Y/105/19/PL & Y/106/19/L

The proposal is for the conversion of, and alterations to, existing barns to create 3 dwellings, along with the erection of car barns, a store, a replacement pump house, demolition of a C20 barn and associated landscaping and parking.

Drawing Title
Proposed Plans - Barn 1

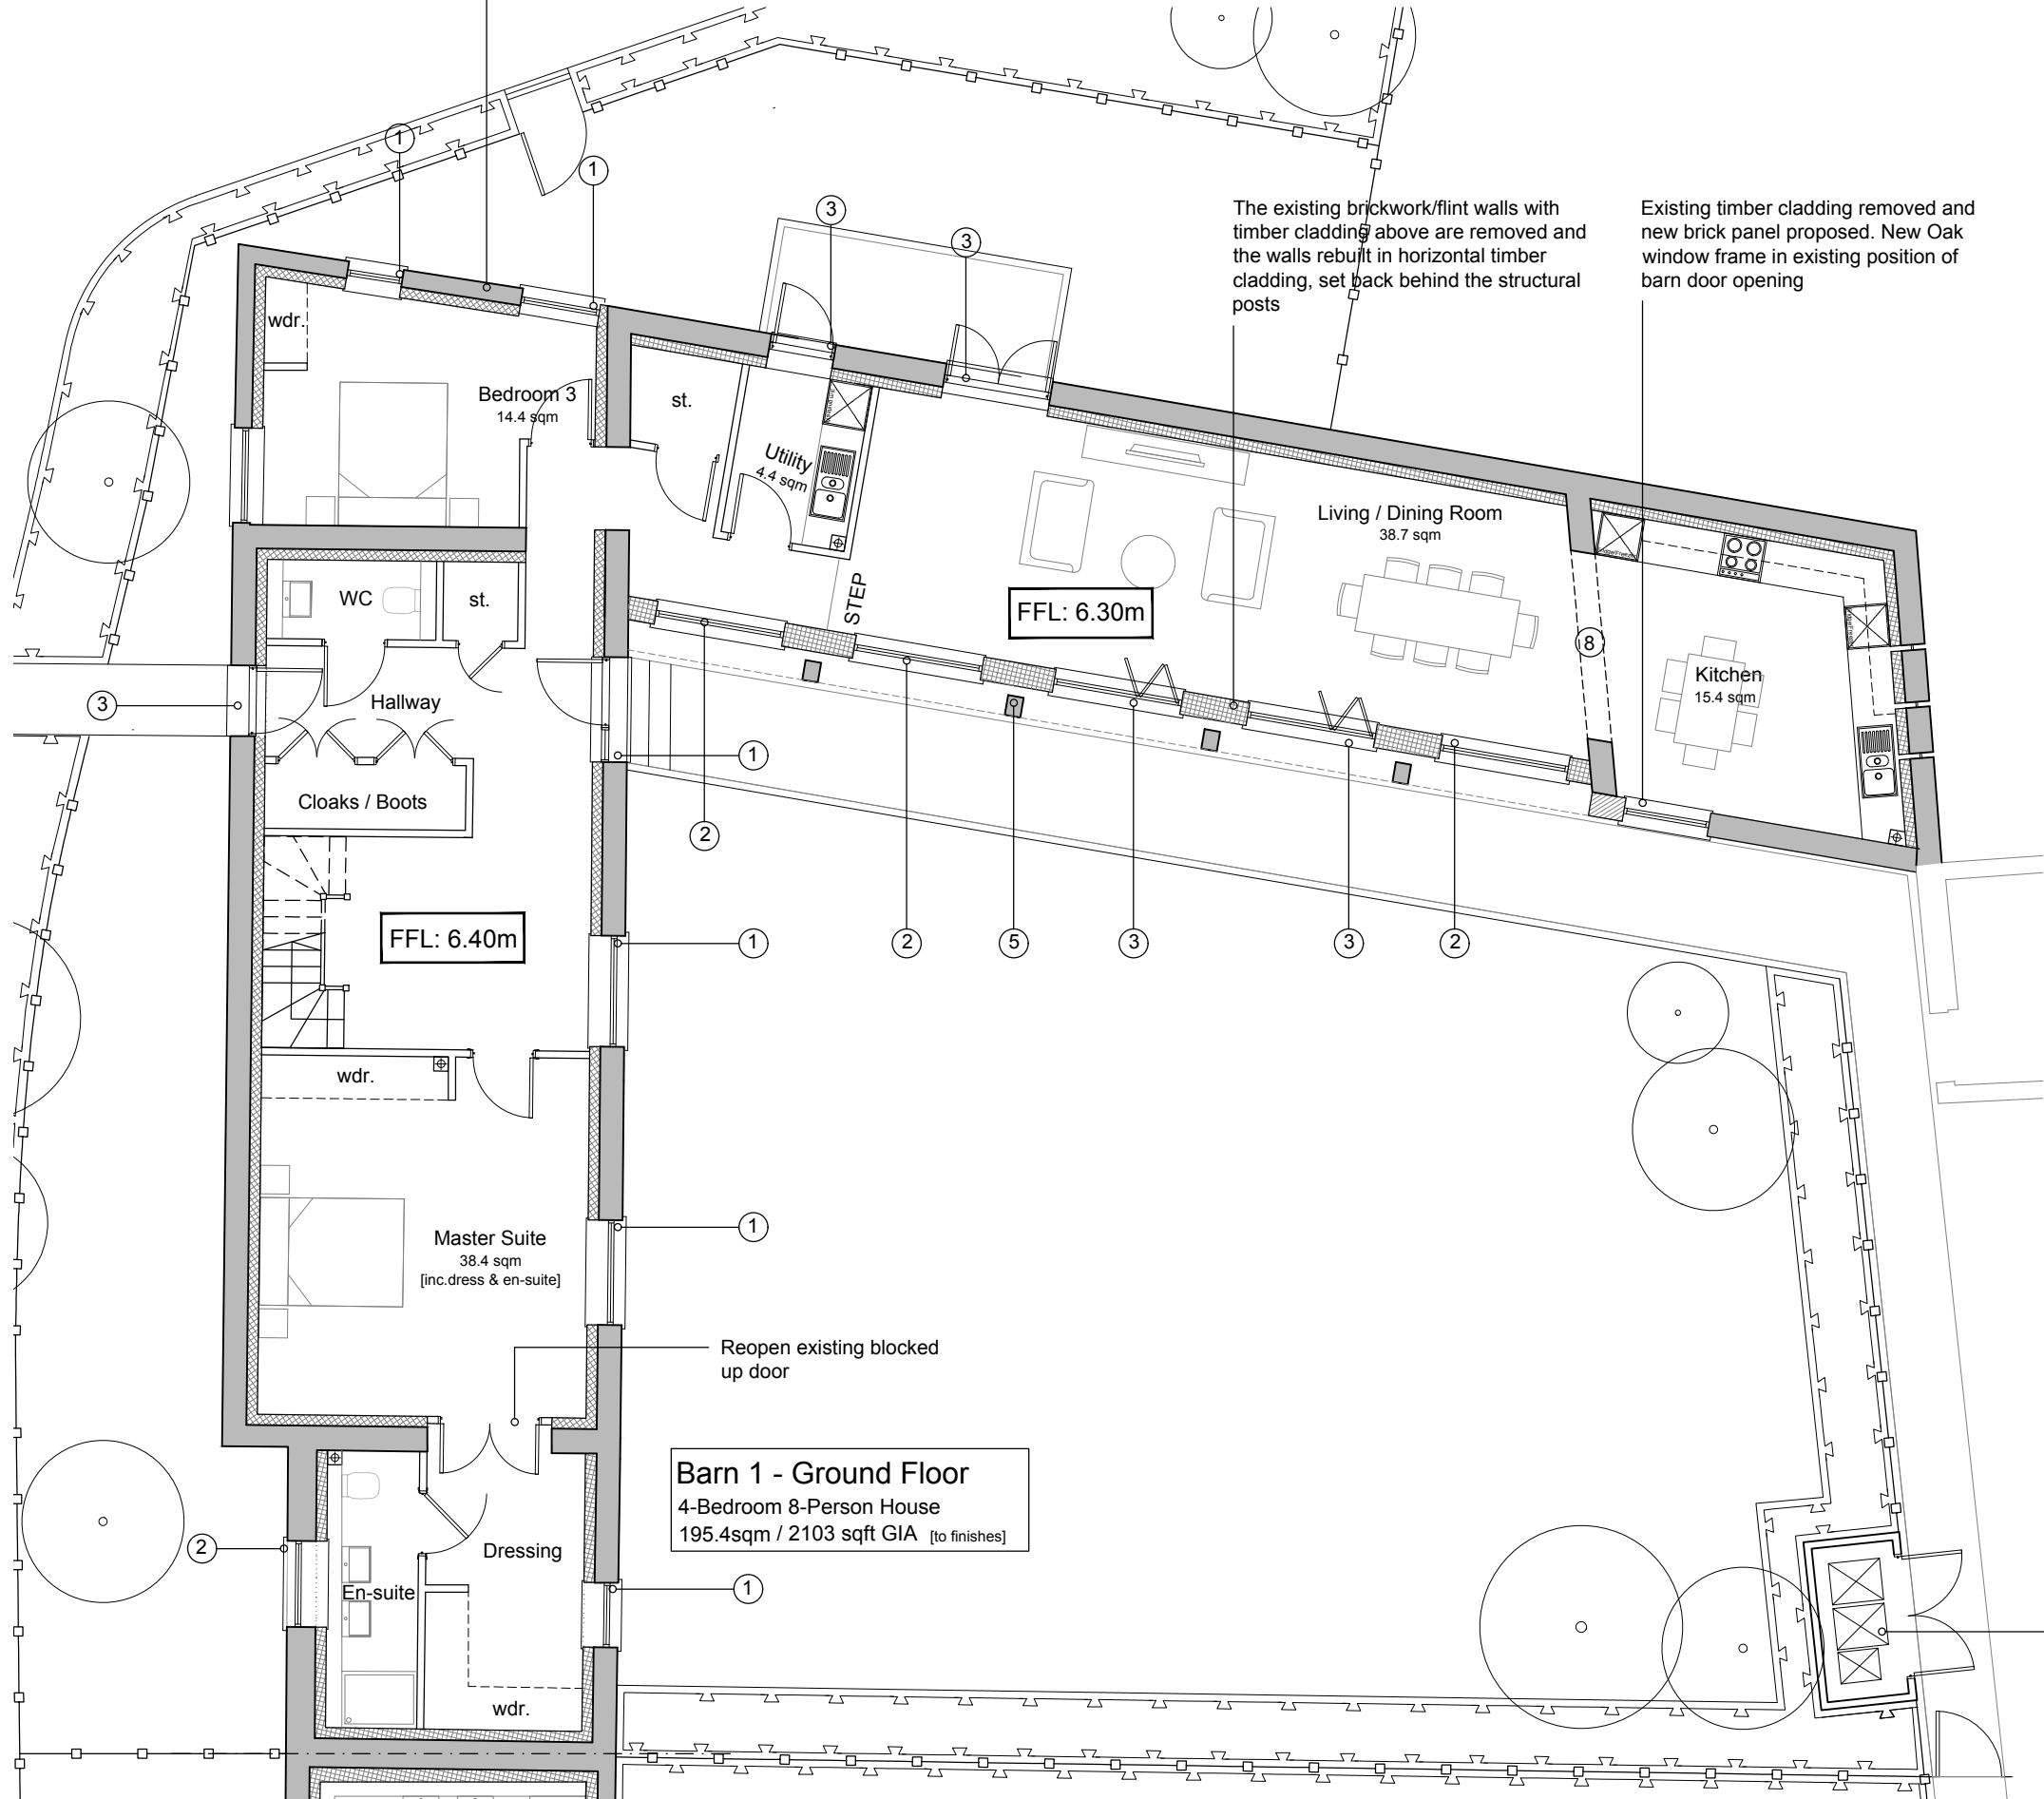
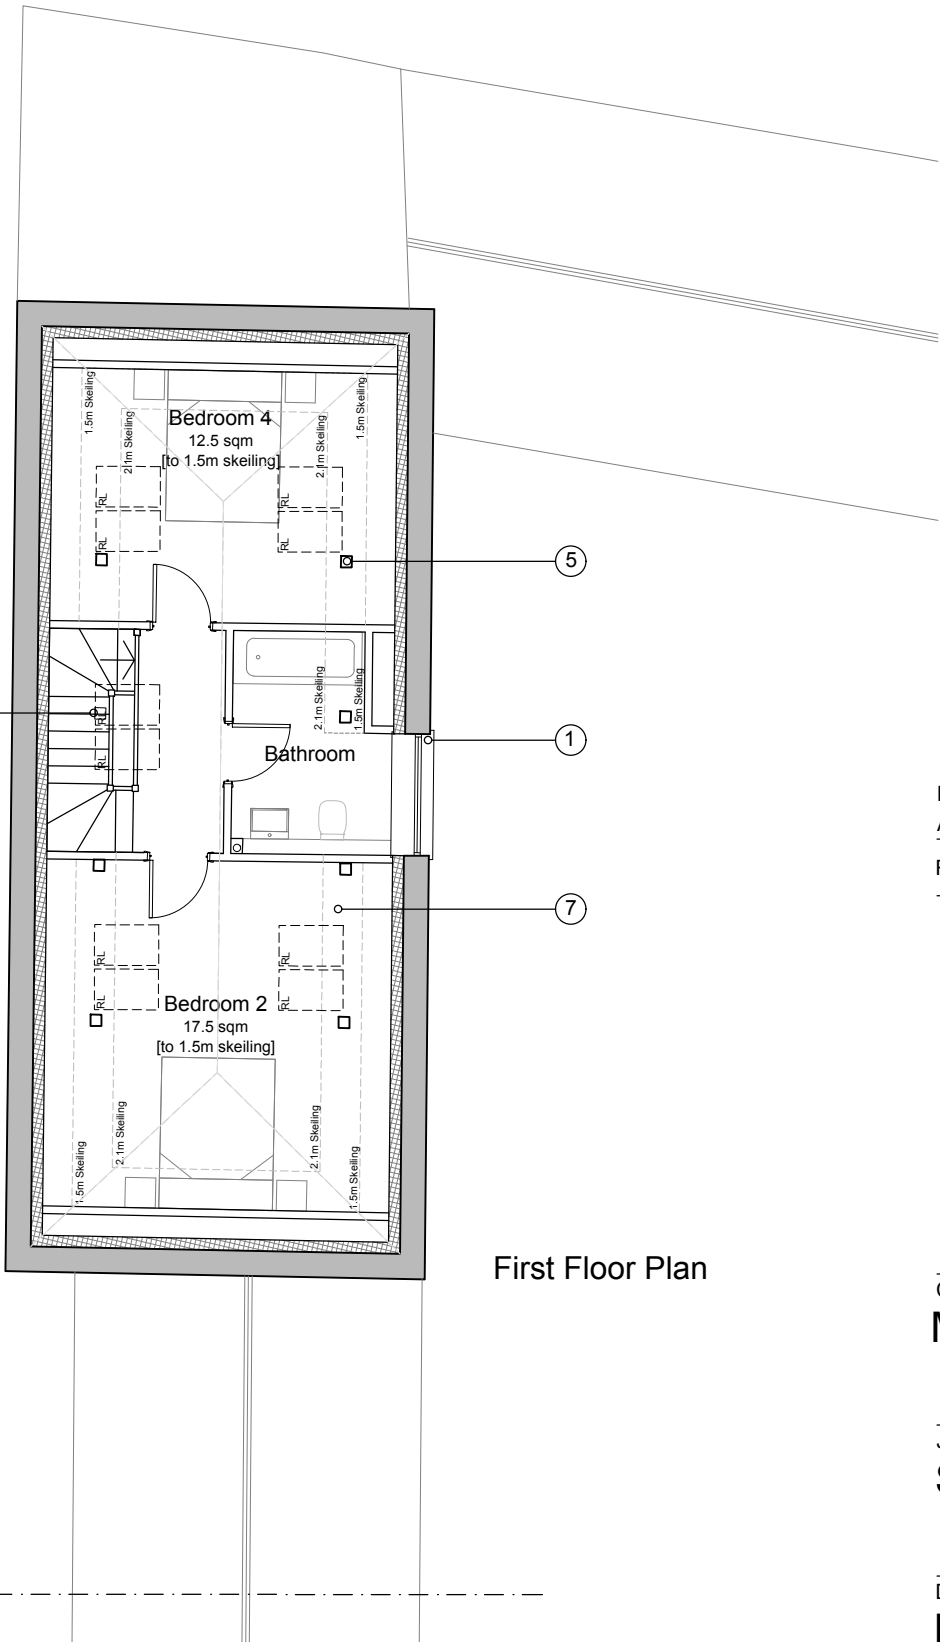
Having undertaken a site visit it is clear that some parts of the barn to be converted into unit one retains some attractive features, especially within the two-storey element. These features are some of the most attractive within the barns. These features include flint flooring, exposed brick walls, timber ceiling and stall dividers. The proposed plans indicate that this area is to be sub-divided up into smaller areas/rooms with a new staircase, yet it is not clear how these important features are to be retained.

Likewise, in building one, it is noted that an elevation will be altered in order to expose the previous cart barn openings. Such a proposal is generally acceptable, but the design of the new elevation, which includes excessive amounts of glazing, should have a simple framed emphasis and be recessed as far as possible to allow a deep shadow line. Such an approach also minimises reflections to reduce the visual prominence of the glazing. This technique can also help to maximise light penetration into the interior. Details of the fenestration along this section of the elevation should be carefully considered in order to ensure that they do not dominate the elevation.

Our design approach has been to accentuate the most attractive features of the barns wherever possible however, but we have had to be realistic on what features we can retain in order to make the houses fit for habitation. For instance, the flint flooring will need to be taken up and appropriate damp proofing, insulation and floor finishes laid to meet building regulation requirements for habitable dwellings. We can however look to re purpose the flint from this area within the car barns or possibly as a feature within the central courtyard space. Similarly, we will need to dress the exposed brick walls with insulation and plasterboard to suitably insulate the dwelling. Whilst the brick wall may not be a feature within the dwelling, this approach will help to protect the wall and offer further longevity to the barns. Where possible the existing timber first floor will be retained as a feature with new insulation and floor finishes dressed on top to meet building regulations for the habitable rooms.

Your comments are noted regarding the window openings and we would assume that they would form part of a planning condition that covers the key construction detailing you wish to be agreed. The window reveals will form part of the detailed design package when the proposed wall build ups are established and we determine how this meets the window/door junctions. In an attempt to reduce the prominence of glazing along the elevation we

could reduce the window sets from three pane to two panes, with the door openings becoming simple double opening doors as opposed to bifold. Please see the attached mark up.

Proposed North-West Elevation (A)

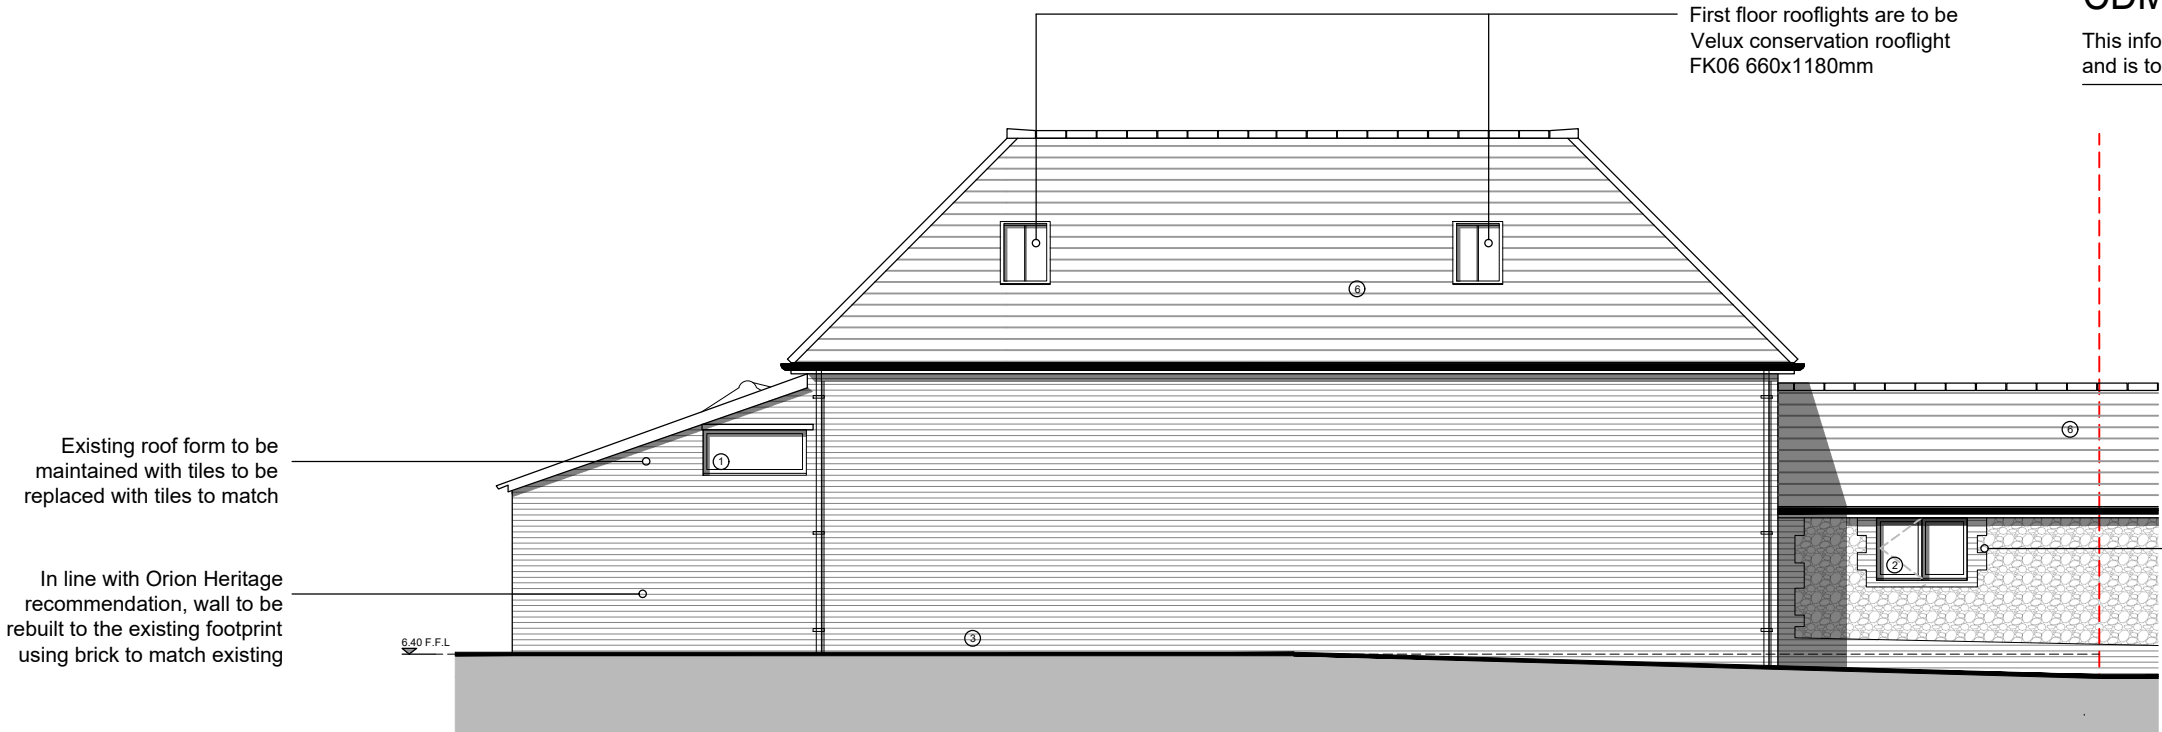
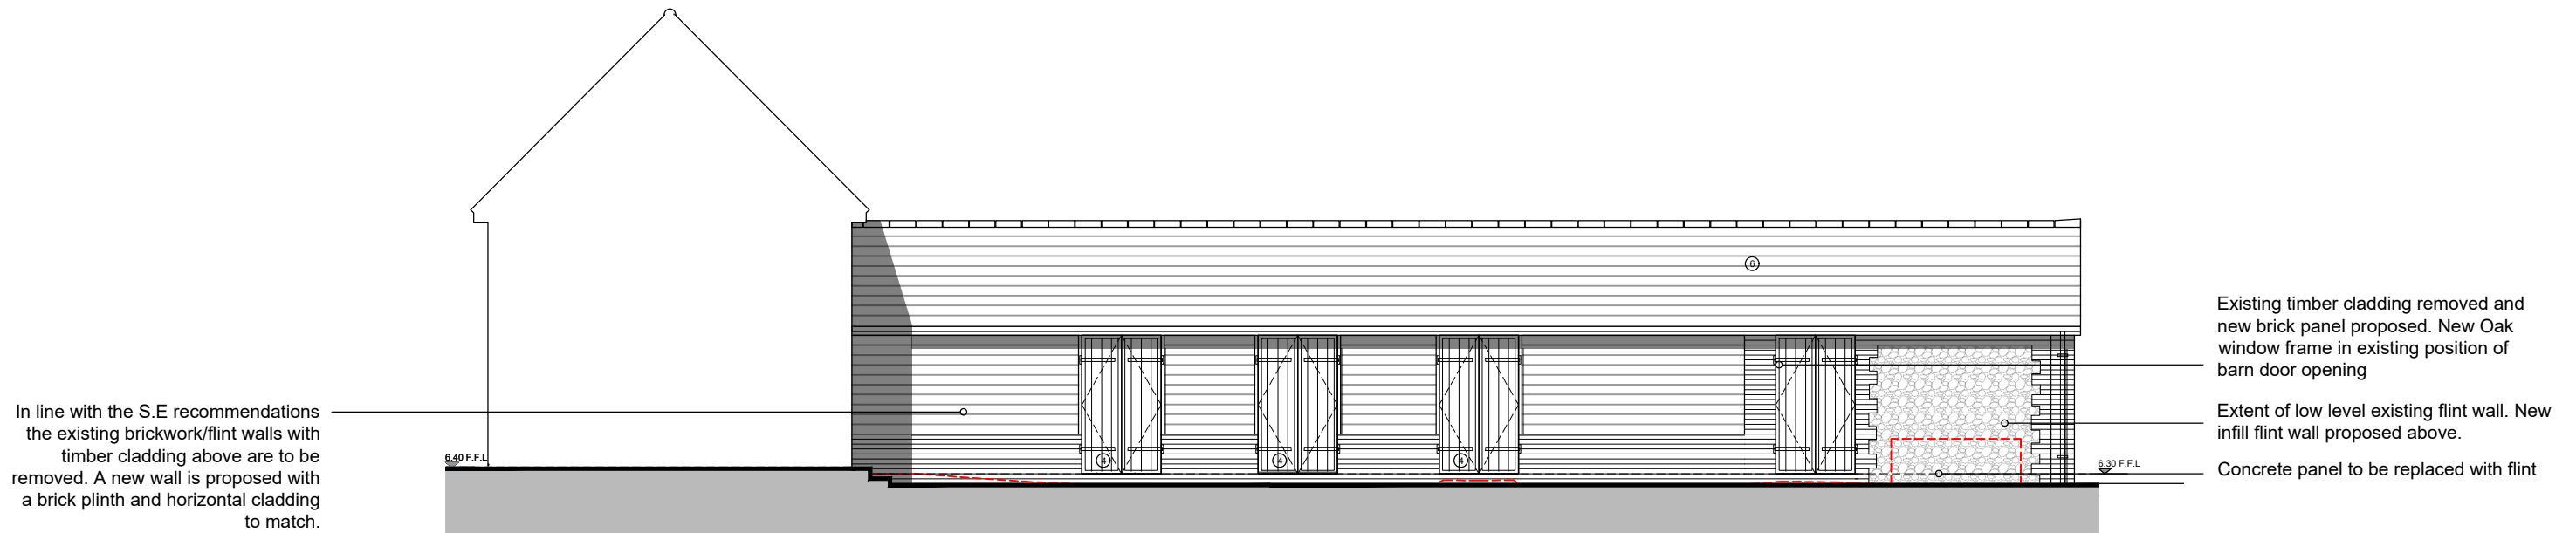
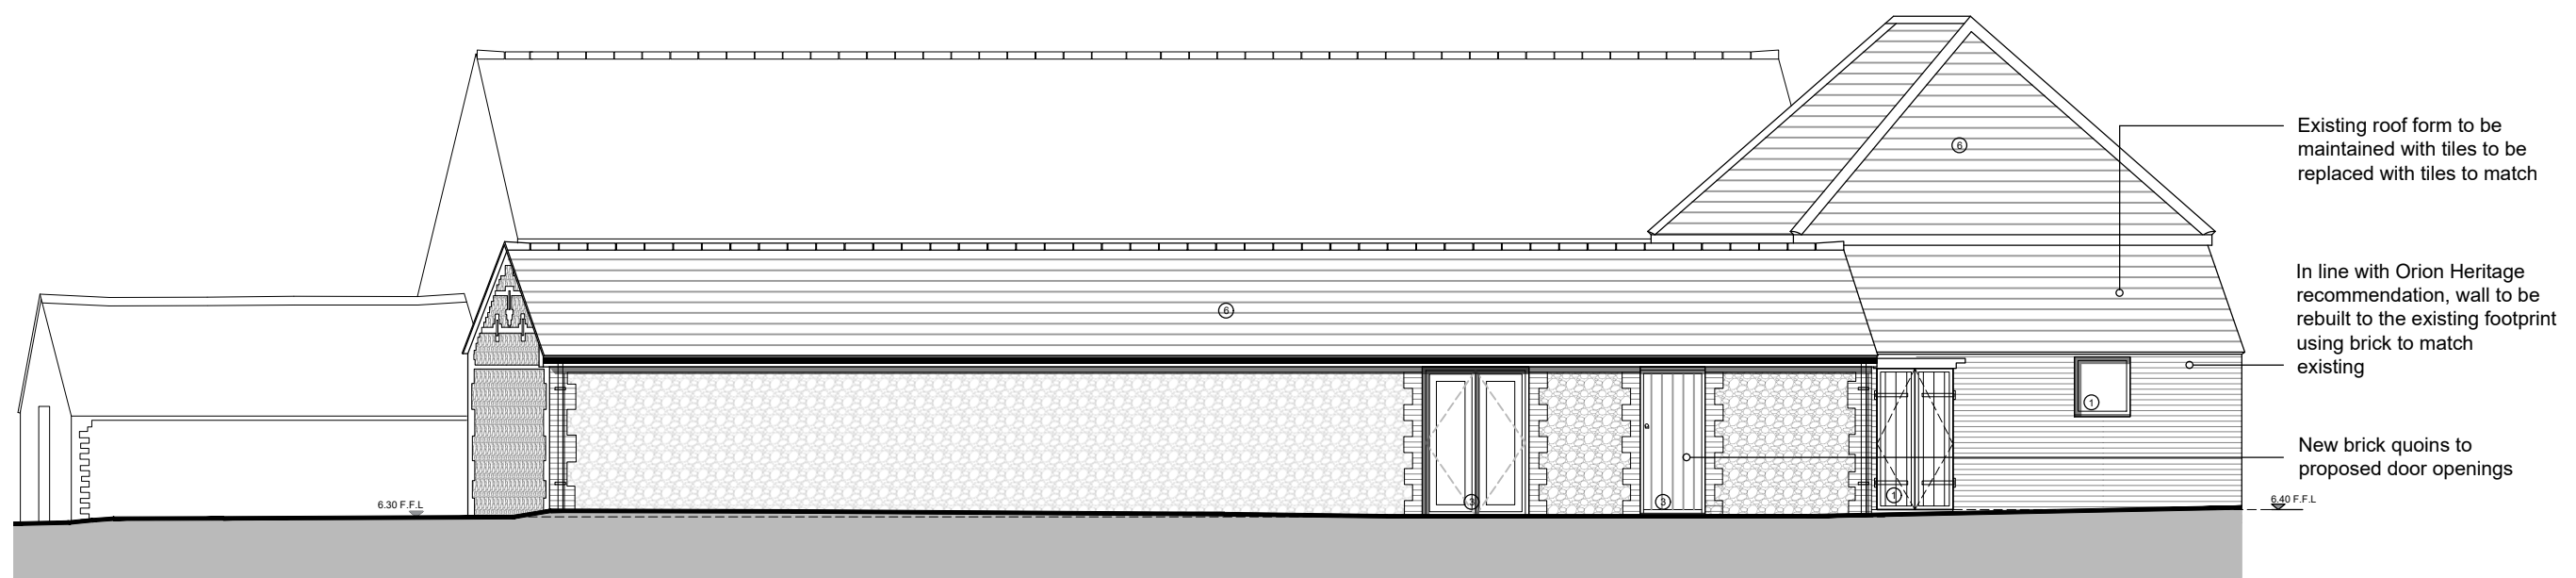
It is noted that the proposals will generally utilise existing openings for windows and doors. Such an approach is positive. However, it is noted that existing doors (or replacements) are not to be incorporated as part of the final scheme. This is unfortunate, as they retain character as part of the building, and are reminders of previous use. Where doors remain, they can be retained and used as shutters; doors can be fixed open in order to ensure that enough light is available to the interior of the building. If in a poor state of repair, they can be repaired or replicated.

There is some concern regarding the amount of rooflights proposed. Are so many necessary?

Whilst your comment is noted we feel that from an architectural perspective the shutters would not be an honest response to the character of the barns. The chosen design response has looked to accentuate the existing and characterful brickwork of the barn and we would argue that the introduction of shutters would obscure this. In addition, due to the condition of the existing timber doors any shutter replacements would be a pastiche attempt at recreating the character, to the detriment of the scheme.

It is intended for these rooflights to be conservation lights which are more sympathetic to the existing character of the barns. With this being said there are some areas within the scheme where the number of rooflight can be reduced, please see our mark-up of the plans an elevation for a suggested solution.
